PLANNING CONSULTATION RESPONSE

Application No	2026/0263
Proposal	2026 0263 Erection of New Dwelling Following Demolition of Existing (Custom Self Build) 28 Tivy Dale Drive Cawthorne
Address	28 Tivy Dale Drive Cawthorne
Date of Consultation Reply	030626
Consultee	Tony Wiles Senior Conservation Officer

Consultation Assessment and Justification

PROPOSED DRAWINGS

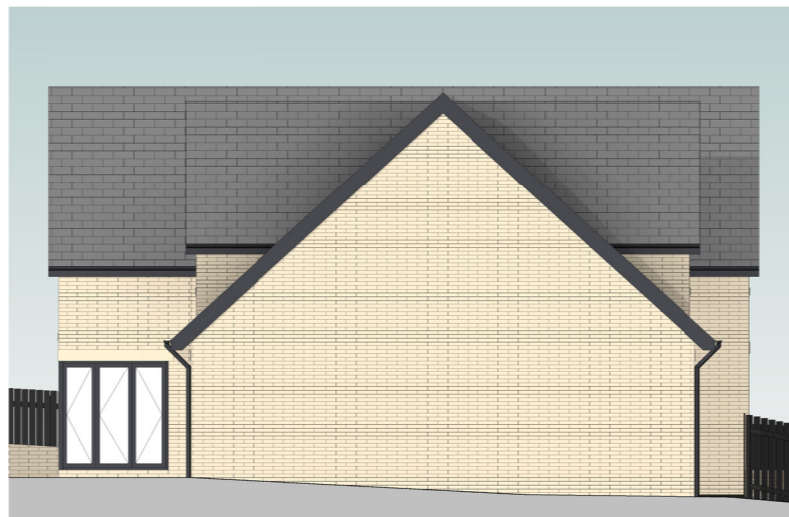
In relation to the proposed replacement dwelling, the submitted scheme indicates a modest increase in both footprint and height when compared with the existing building, being approximately 2.3 metres deeper in plan, with an increase in eaves height of 352mm and ridge height of 1300mm. Notwithstanding these changes, the proposal would remain, in essence, a one-and-a-half storey dwelling incorporating broad gabled dormers and gable features. The roof form assists in visually breaking up and moderating the perceived scale and massing of the building and. Taken as a whole, the increase is considered to result in only limited additional intrusion into the setting of both the conservation area and the registered park and garden. The roof is shown to be finished in what appears to be slate. My preference would be for sandstone roofing slates, rather than blue or grey slate, or alternatively a good-quality riven artificial product. This reflects materials more characteristic of Cawthorne and also evident within more recent developments on Tivy Dale Drive. This matter should therefore either be clarified through the application / amendment or controlled by condition. The external walls are described as coursed stone; however, the preferred specification would be natural square-coursed sandstone with a split-face or pitched-face finish. The fenestration is generally simple in form, comprising principally casement windows of a restrained design and appearance. The main exception is the large, glazed opening within the north-facing gable, together with the bank of ground-floor windows to the rear (west) elevation. Whilst the northern elevation faces away from the conservation area, it does face towards the registered park and garden. On balance, however, having regard to the extent and nature of visibility from the surrounding landscape, this is considered acceptable in this instance. Overall, the proposed dwelling is architecturally more resolved and draws clearer reference from positive building characteristics found within the adjacent conservation area. Accordingly, I raise no objection to the proposal and consider that it accords with Section 72(1) of the Act, Local Plan Policy HE1 and HE4, and paragraph 212 of the NPPF. For completeness, I recommend that the external material specifications are either clarified through amended details or secured by condition in accordance with the suggestions set out below.

- Before Commencement / Upon commencement of the development, all external materials used in the development shall be submitted and approved in writing by the Local Planning Authority.
- Walls shall be constructed in square coursed natural sandstone with a split faced / pitched faced dressing
- The roof shall be covered with natural / good quality artificial sandstone roofing slates laid in diminishing courses with matching ridge tiles.
- Windows and doors shall be mounted in the reveal a minimum of 100mm.
